AL/14/20/HH

Proposed enclosure of open sided carport (This application may affect the character and appearance of the Norton Lane Conservation Area)

PLANS & ELEVATIONS

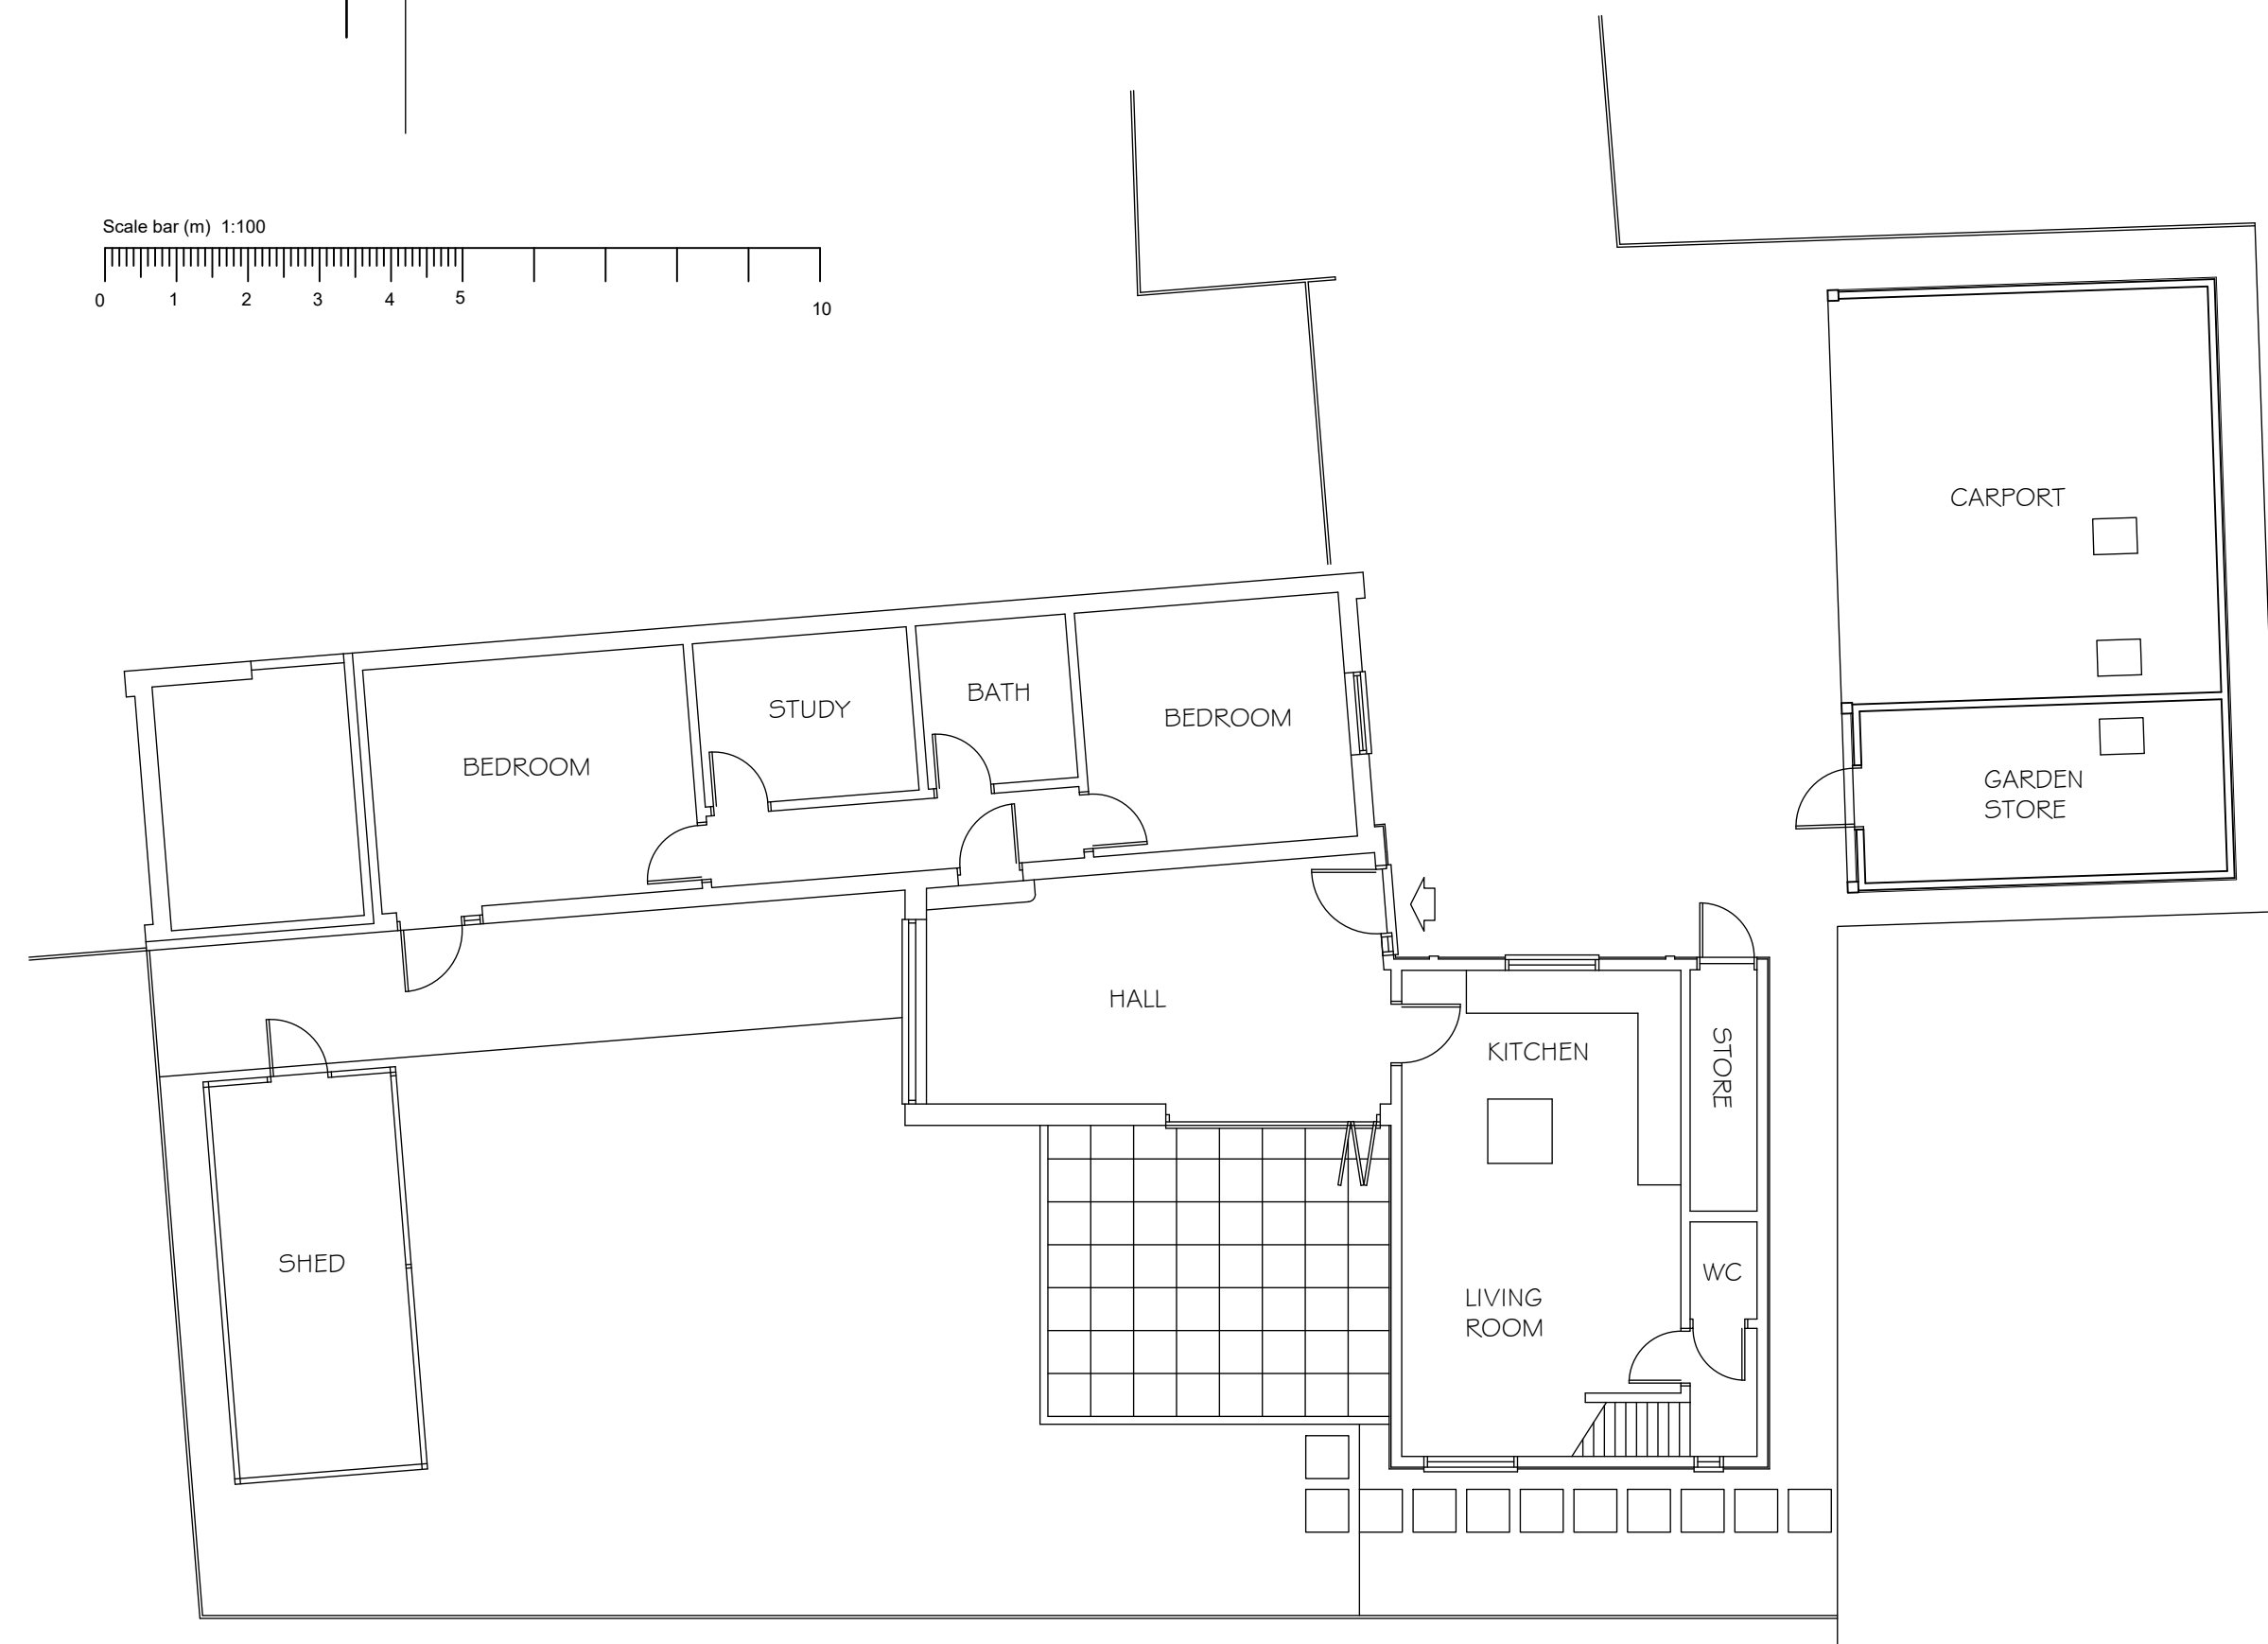
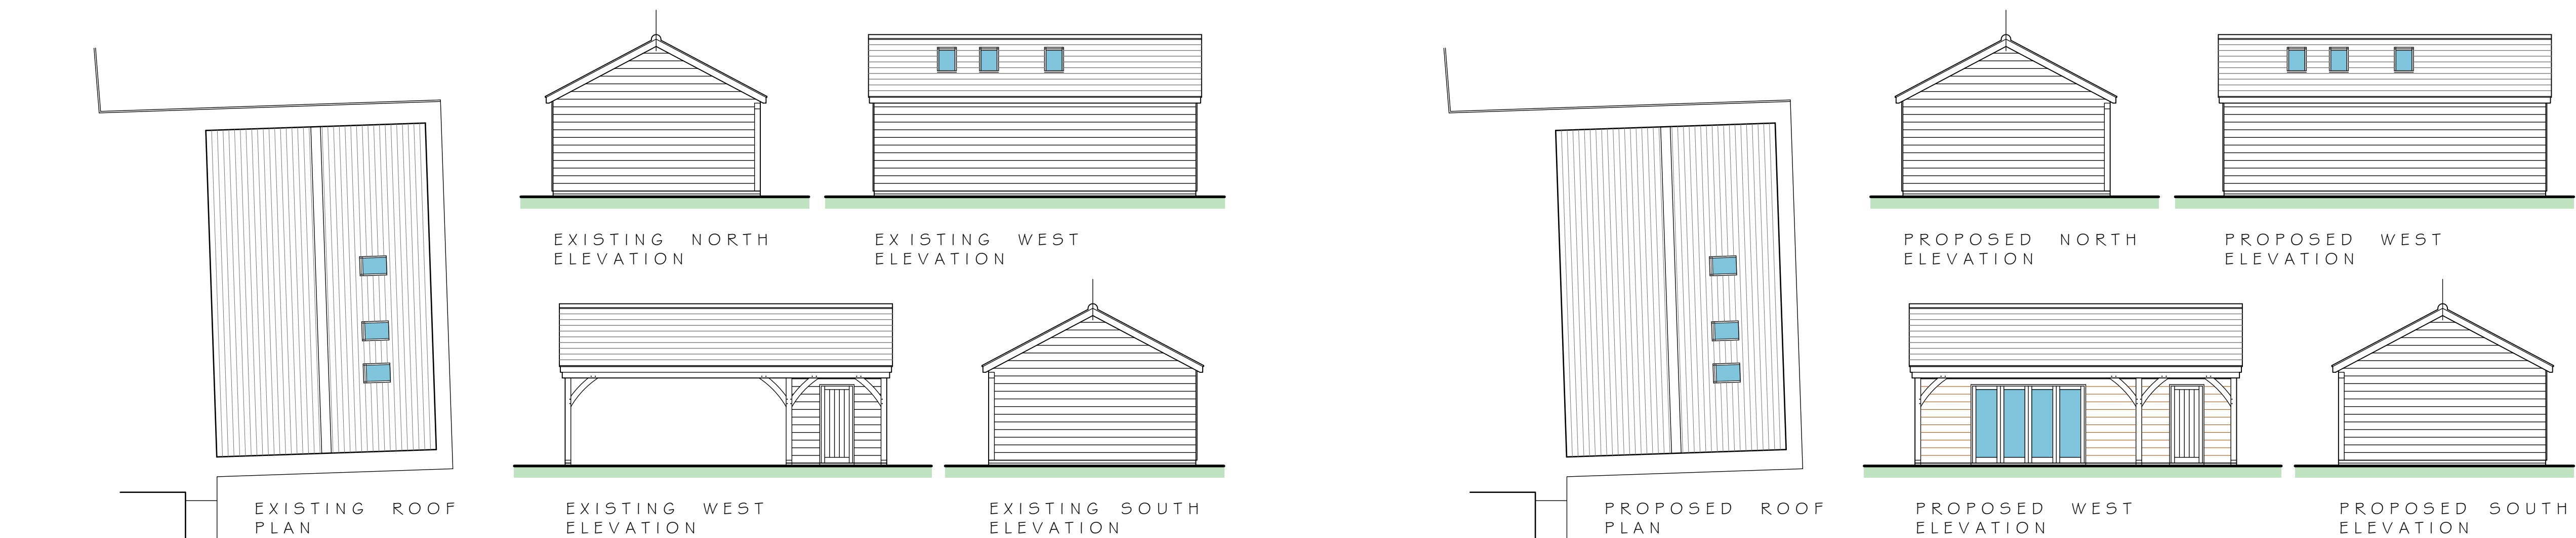
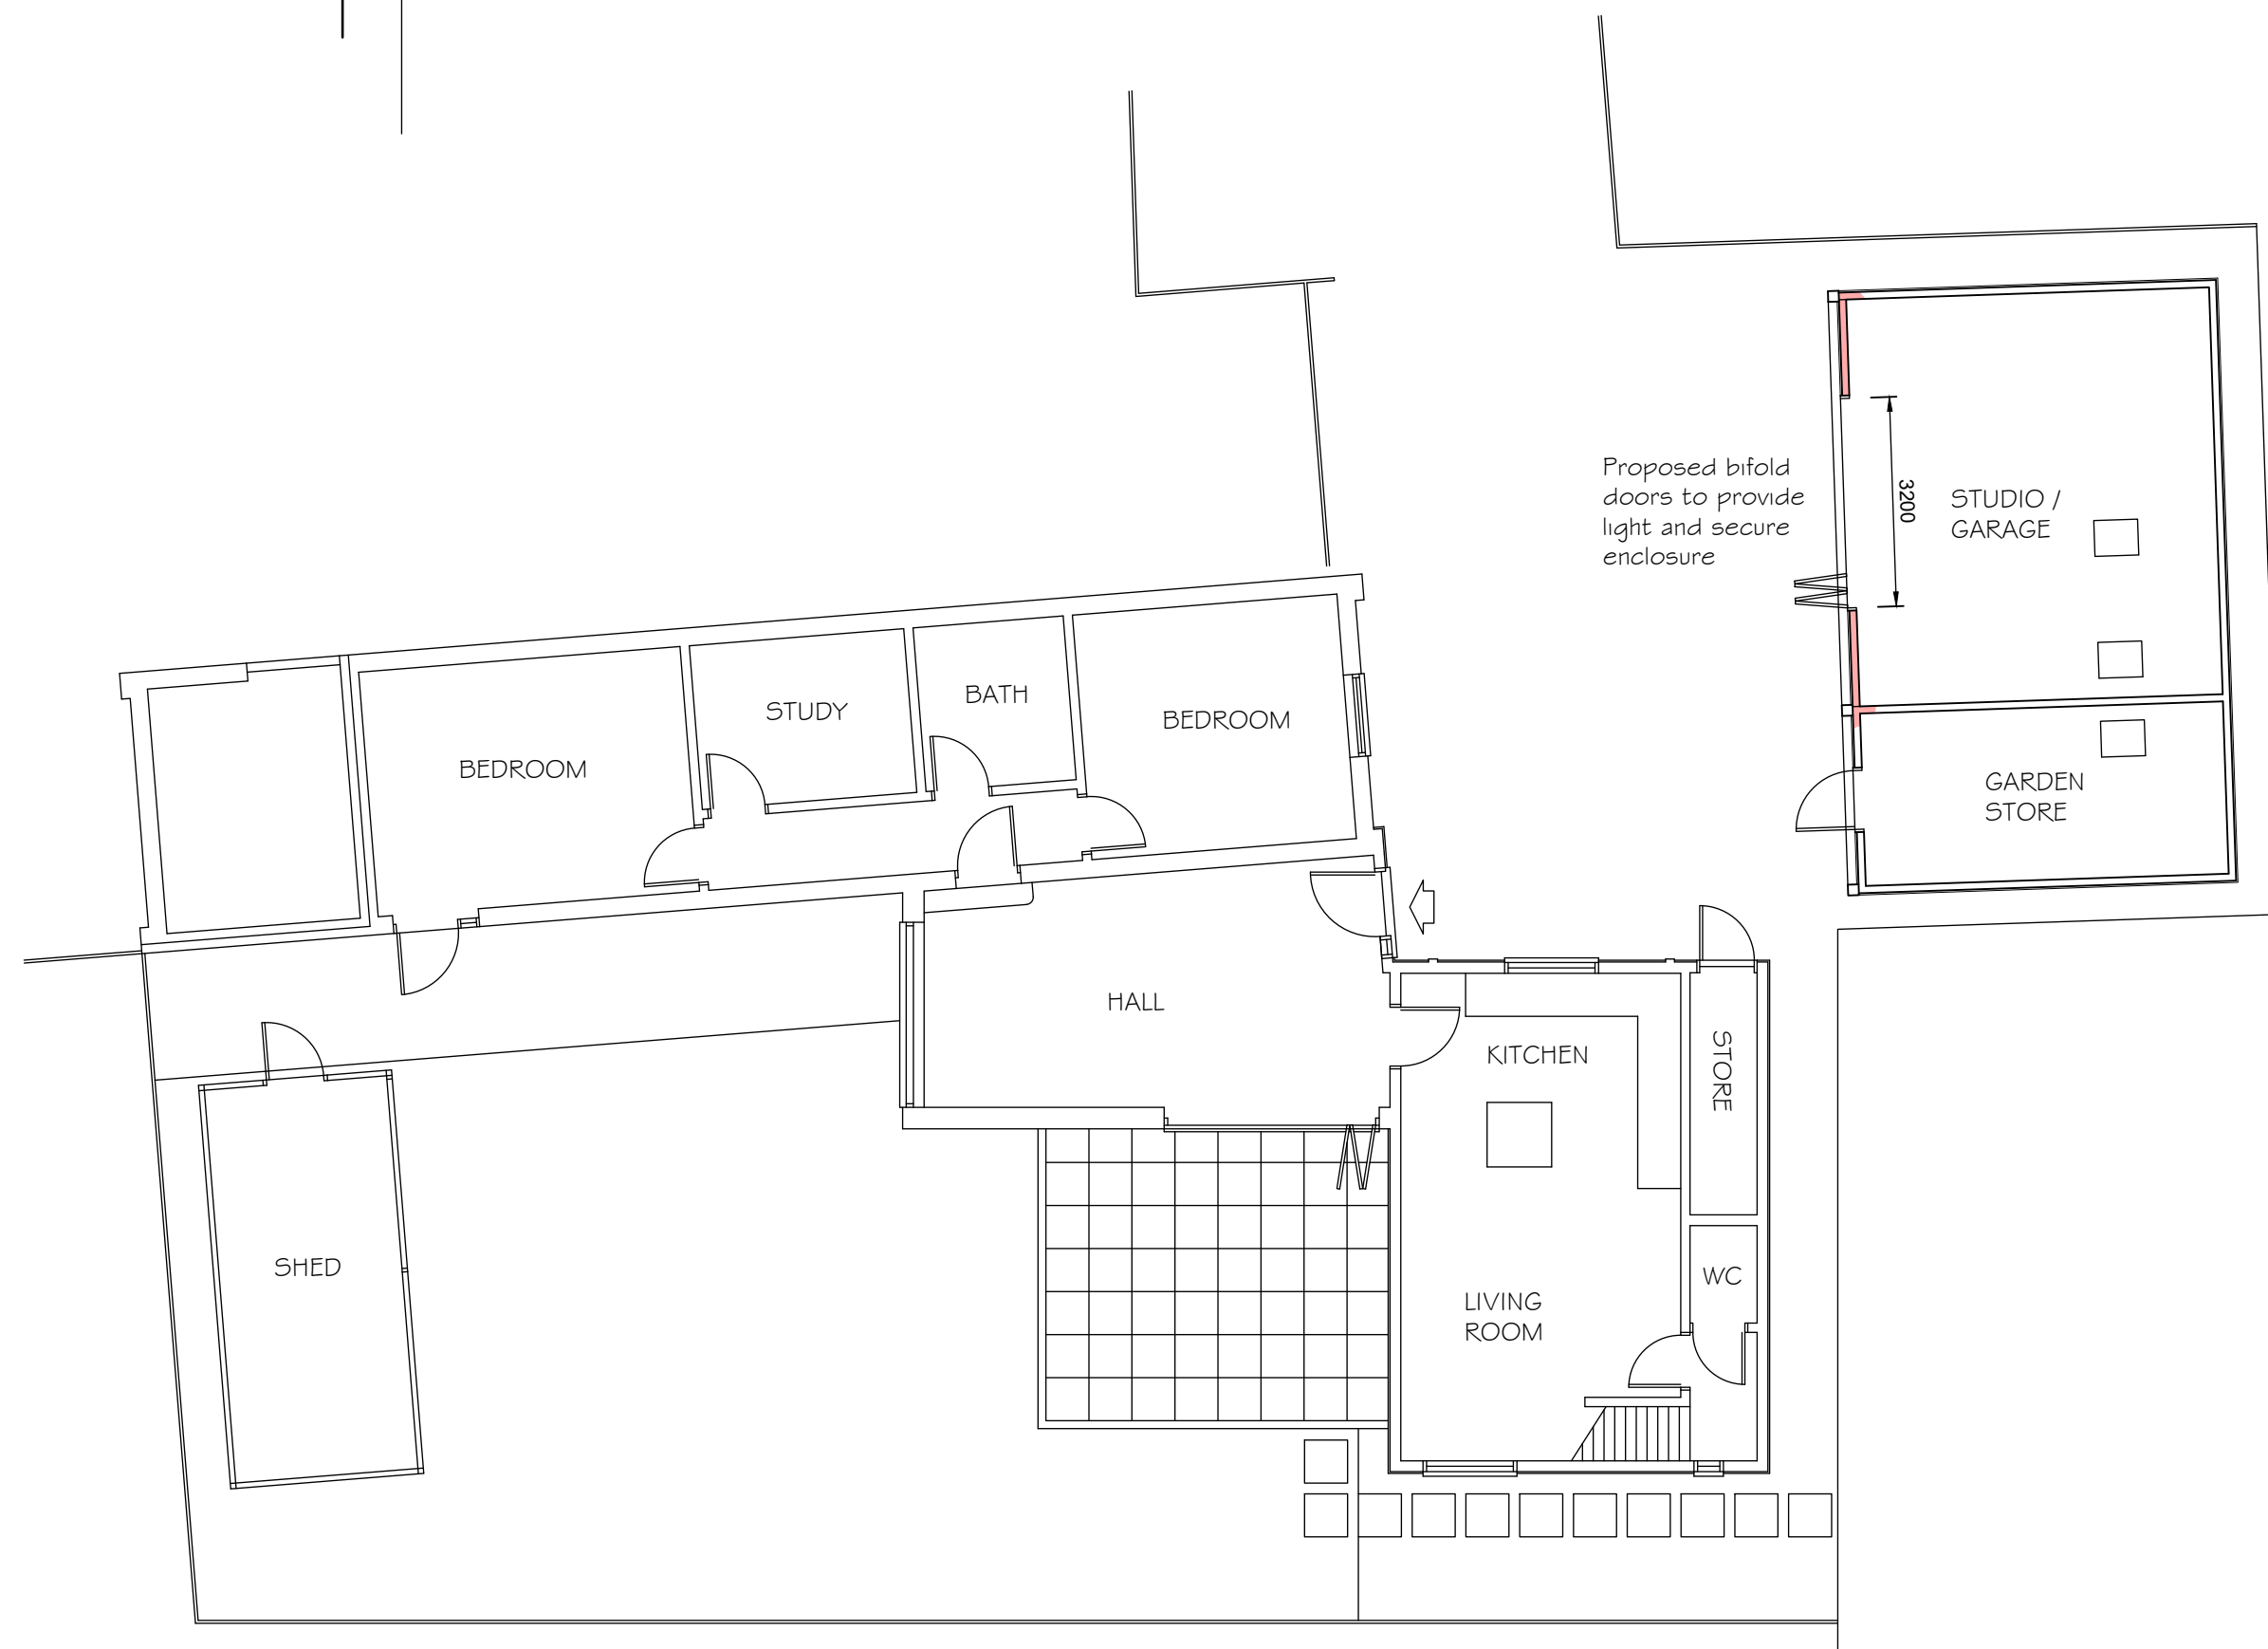
The proposal is to enclose an open sided carport so that it can be used as part of the residential accommodation. It is assumed that the space will form more of a studio space based on the intended means of enclosing the structure i.e. bi-fold doors. Such a proposal would reflect the character of both the site and surrounding area and would not result in any harm. This is on the basis that the joinery and materials should match that already on the site in terms of materials, appearance and colour.
